Dear Sir/Madam,
RE: Lots 18, 20 36, 37, 38,39, 40 & 41 of SP 74416 - 85 George Street,
Parramatta - Proposed Development of 89 George
Street, Parramatta.

**RE: Objection to Proposed development
No 89 George Street Parramatta
Your Reference: MP 09_0128 - Commercial Retail Development**

Planning Direction has been engaged by *Strata Plus Pty Ltd* (Managing Agents for the owners of property No 85 George Street Parramatta.) to review the above development application and to provide advice in respect of the town planning aspects of the proposed development.

55m ABOVE NATURAL GROUND

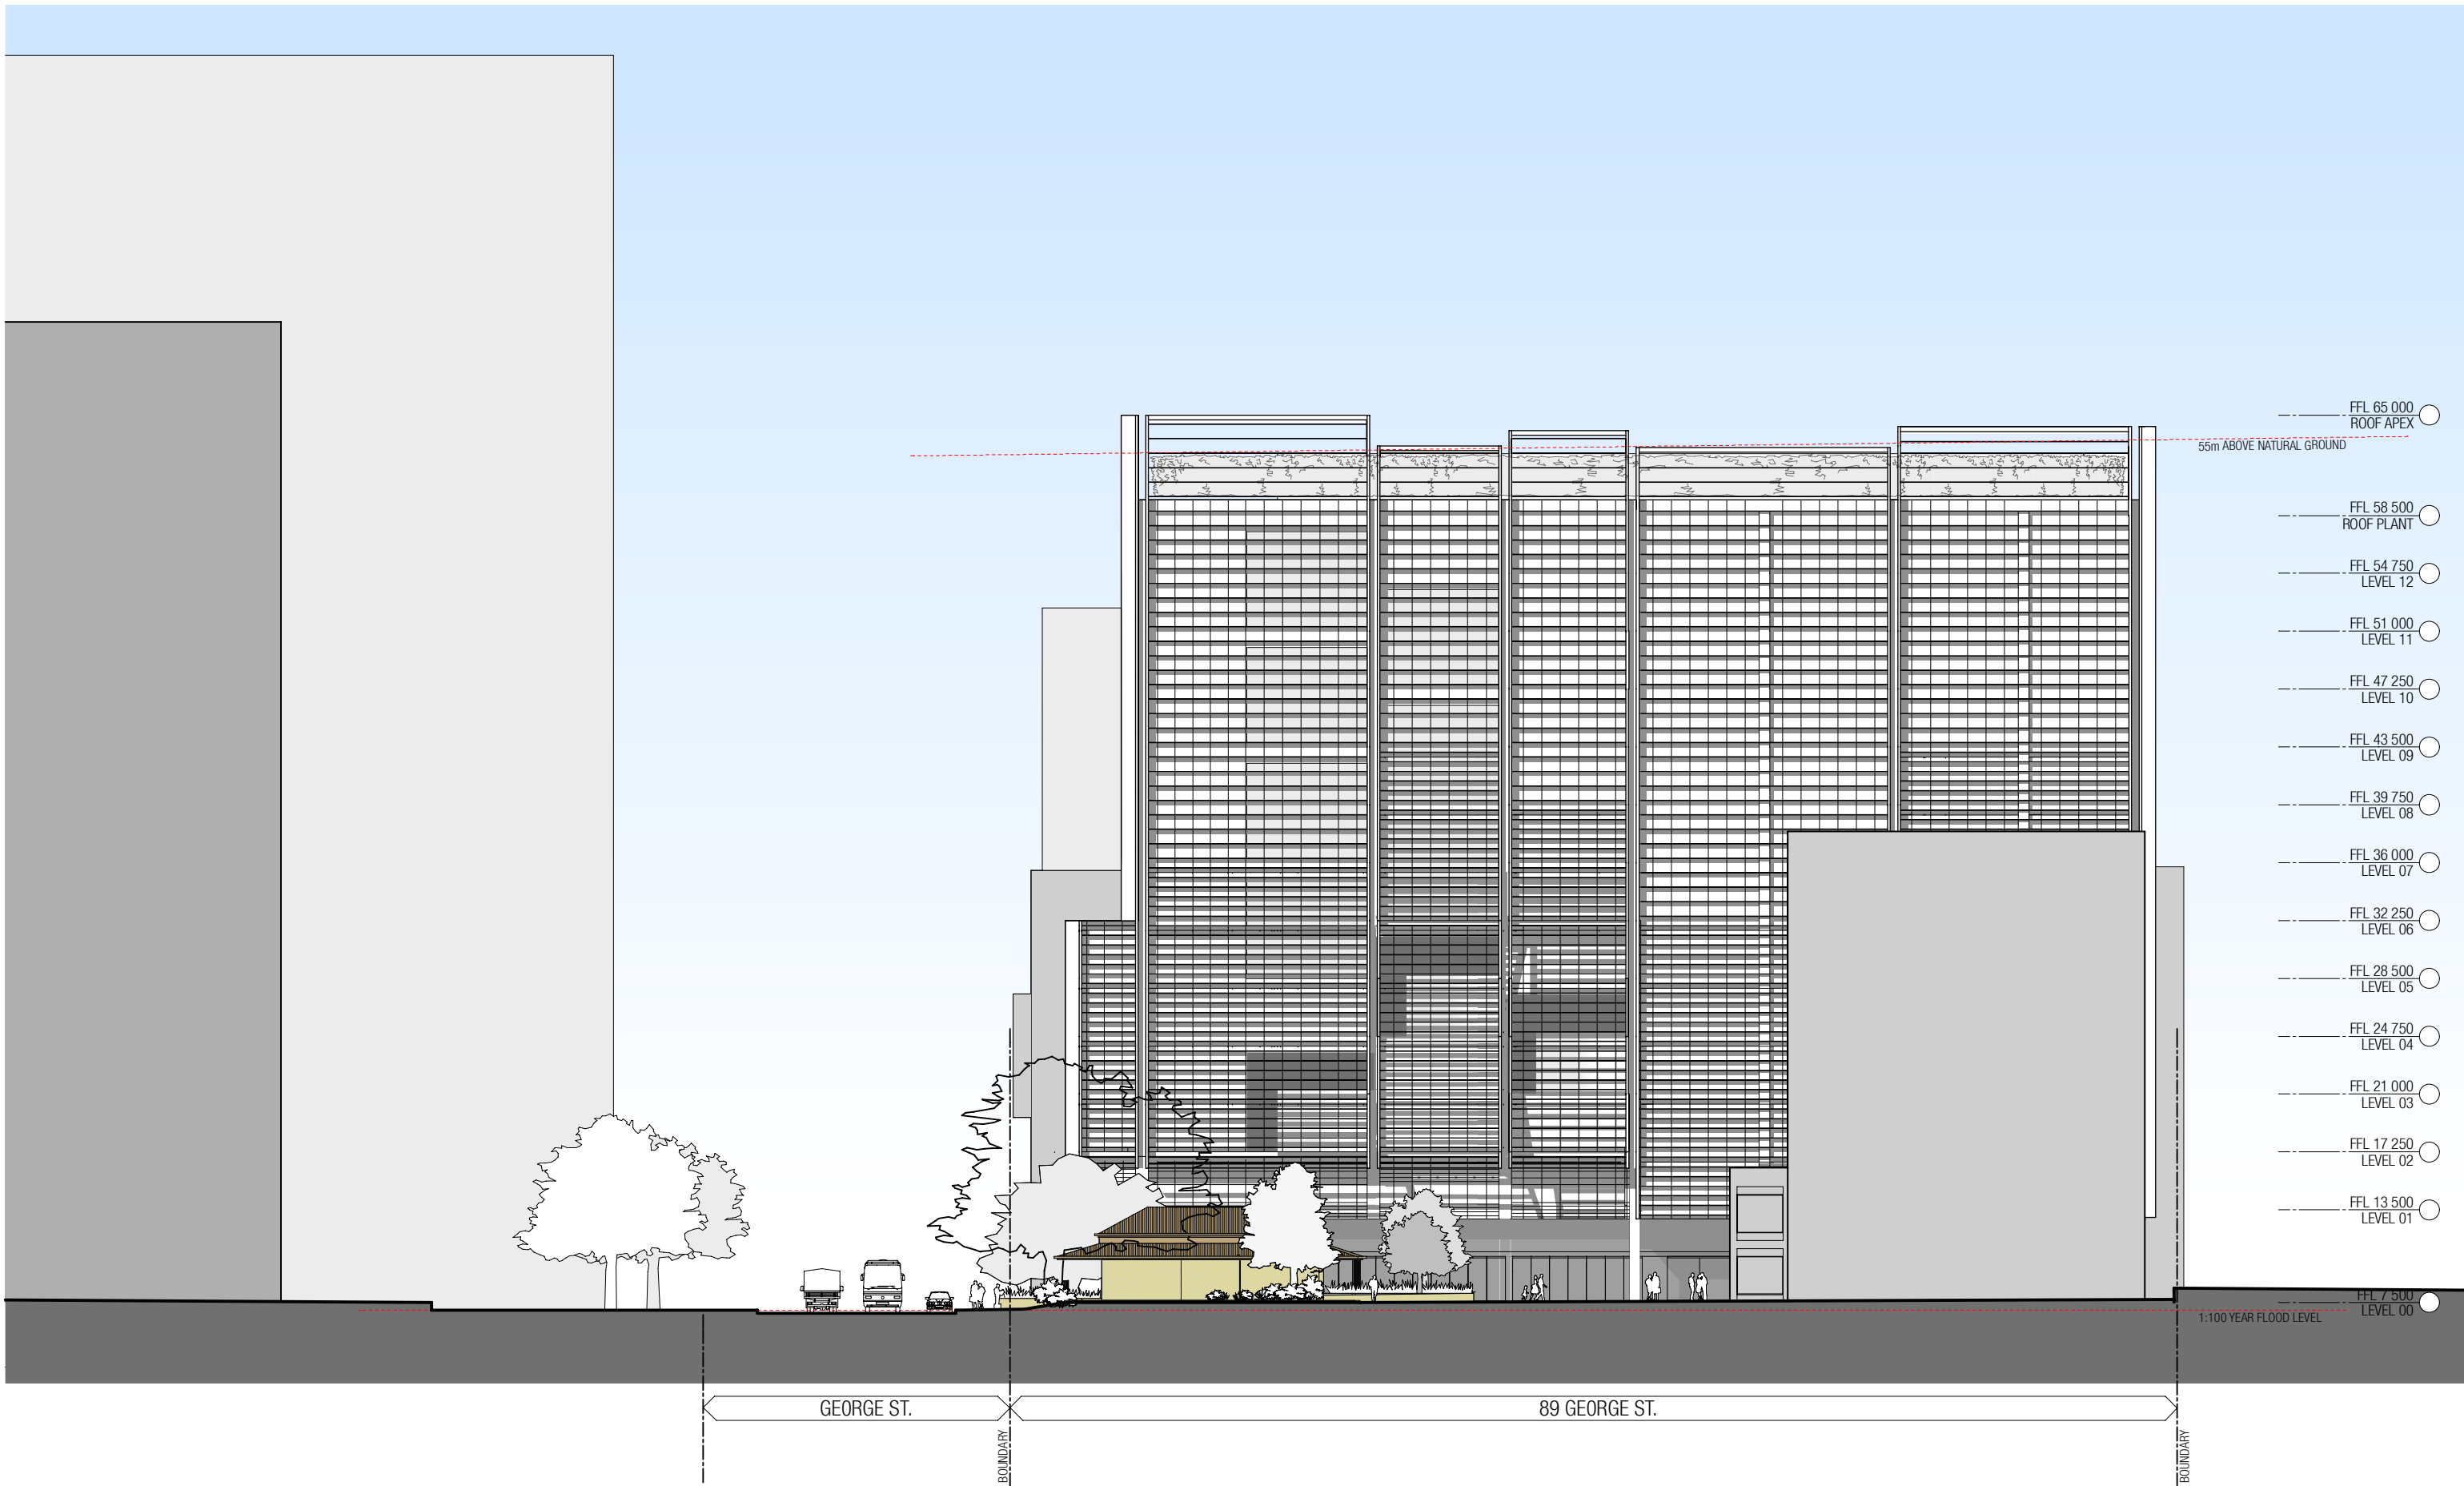
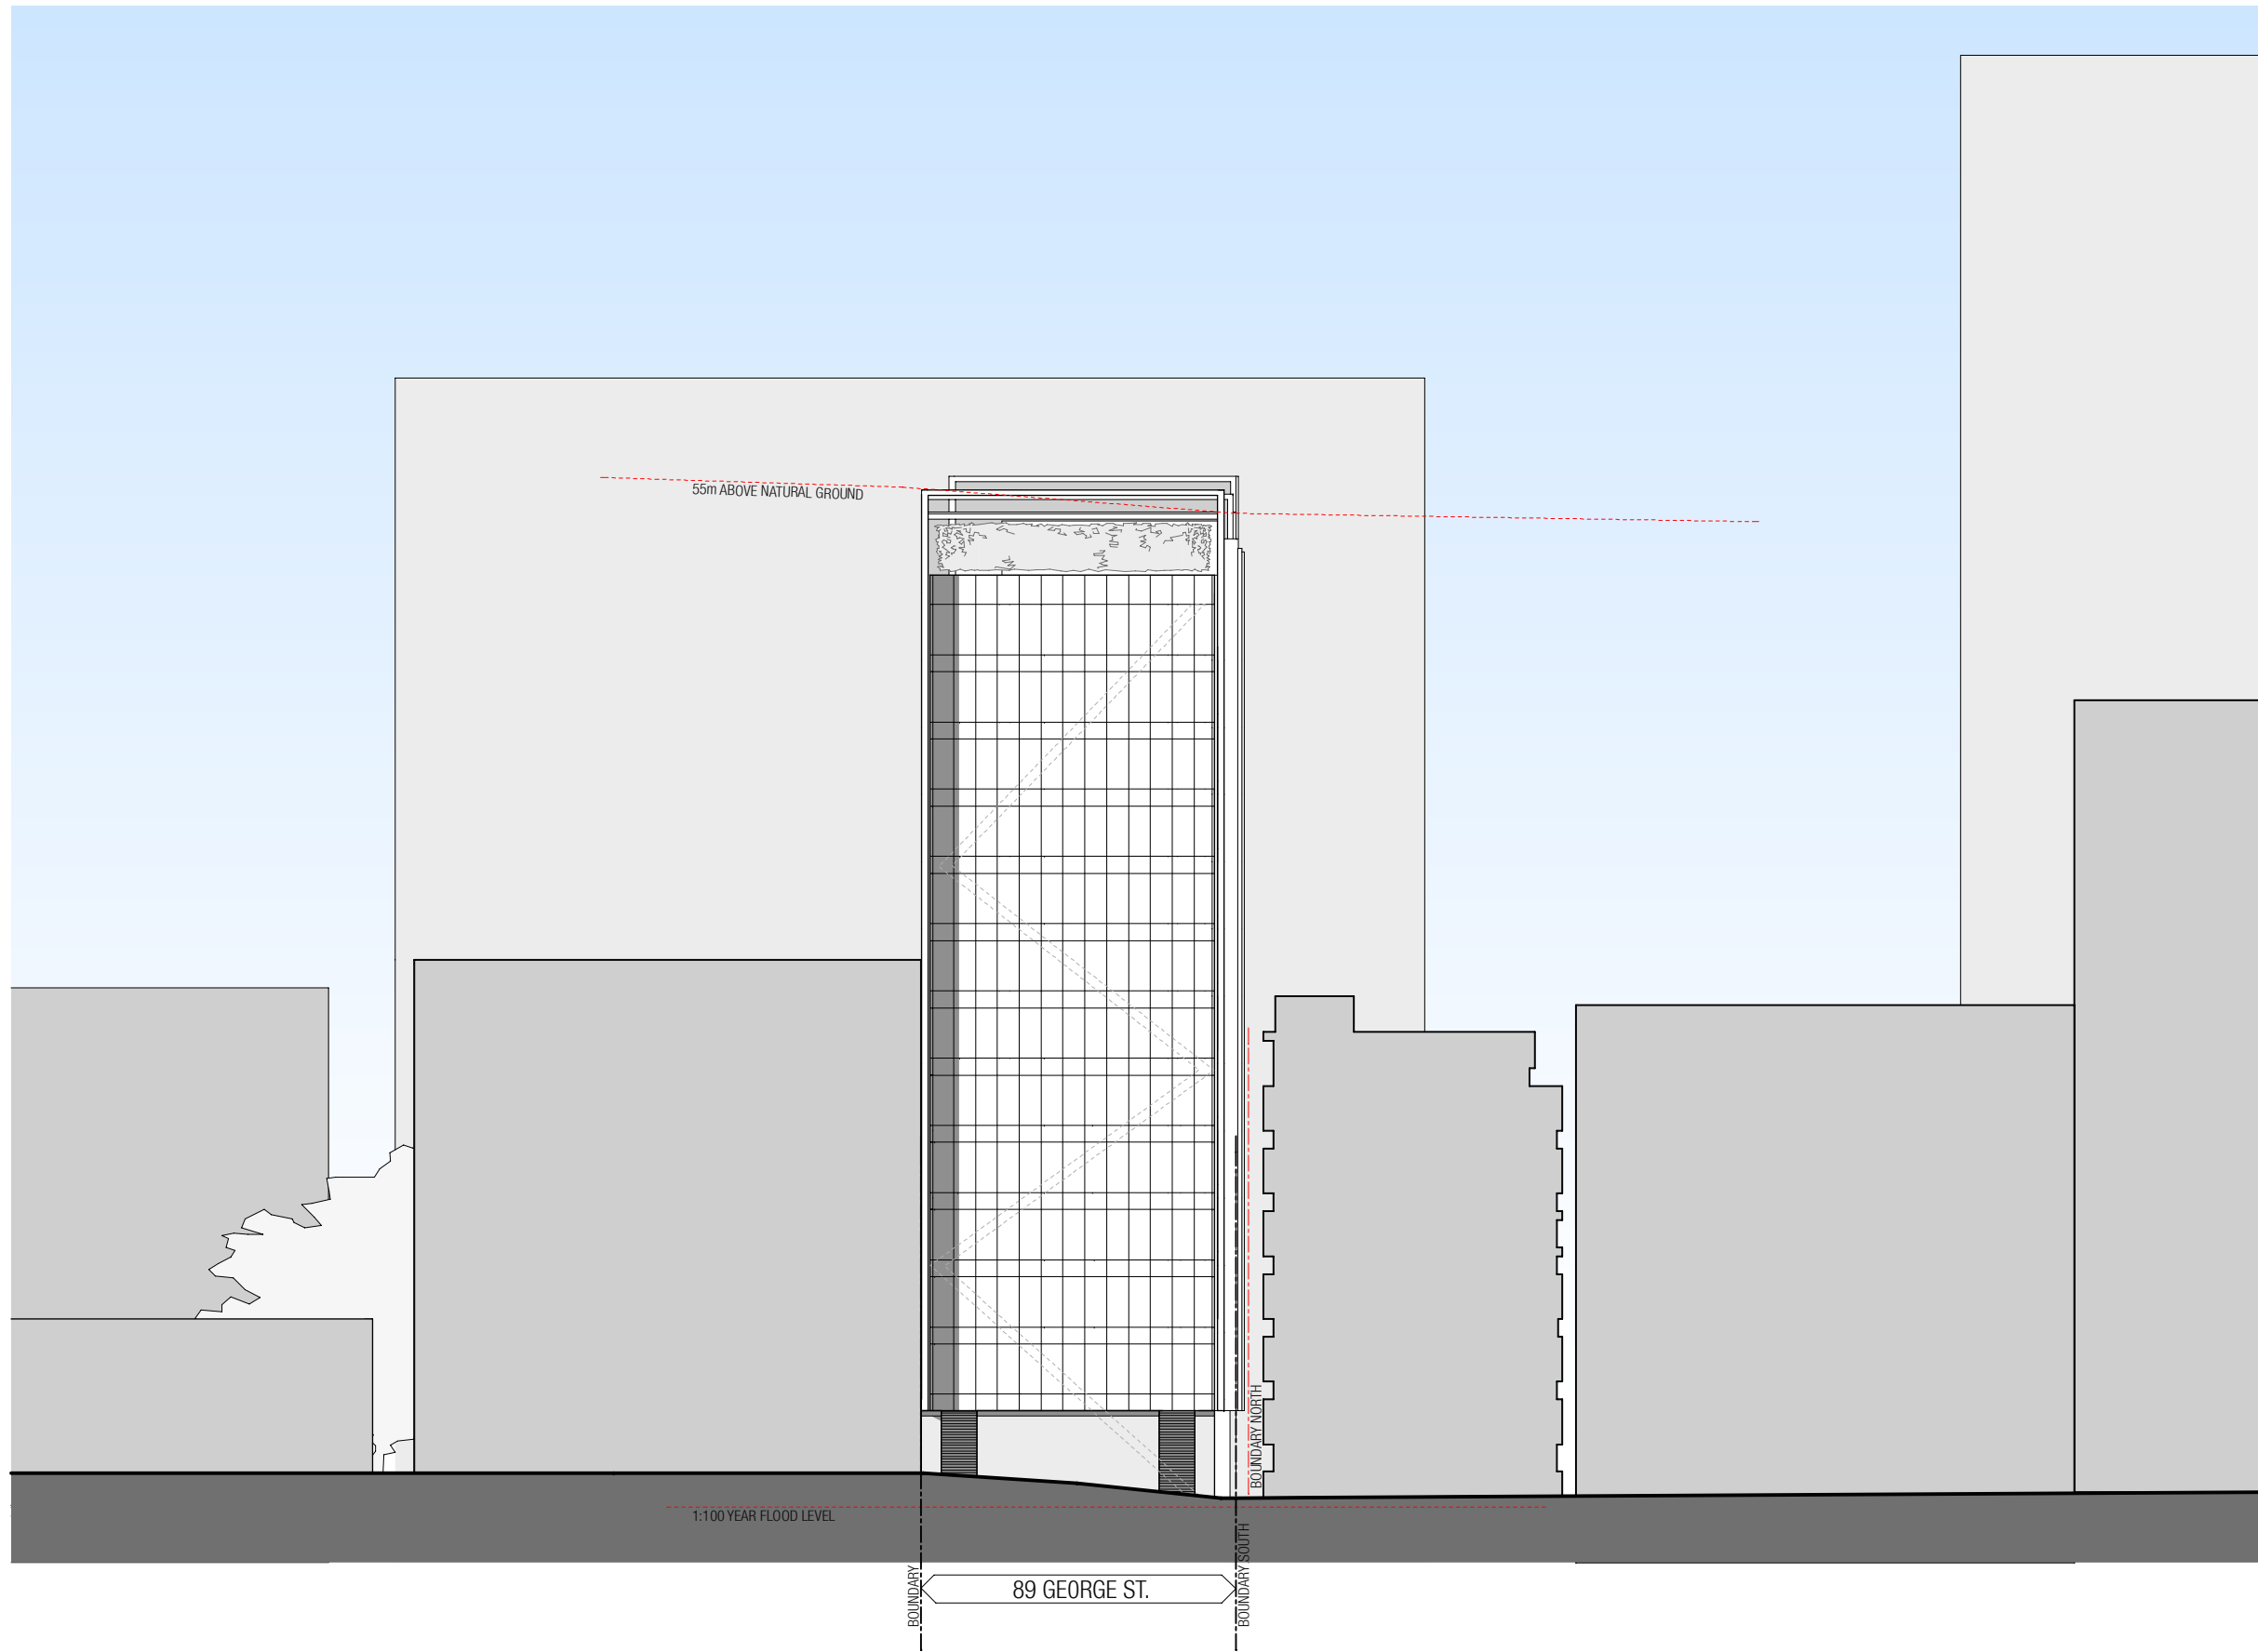
Rather than respond to the established development pattern, the design proposal presents a continuous high rise building wall immediately adjacent to Perth House rising in height to a thirteen storeys (or 55m) and with a wall length of some 75m. The constrained width of the site and non compliance with building setback and building separation controls reduce the opportunity for effective building articulation.

The development will not enhance and protect the existing landscaped setting and well established curtilage of Perth House, it will ‘stand over’ and ‘overwhelm’ Perth House and its grounds severely compromising its heritage significance and streetscape value.

In this respect the proponents expert reports have advised that the proposed variation to the maximum FSR control manifests in an additional 3 storeys commenting “*Strict enforcement of the FSR standard would result in the loss of 3 levels of floor space*”. The additional three floors significantly increase the building bulk and mass. The additional floor space is squeezed into a very constrained development site and this manifests in unacceptable adverse impacts.
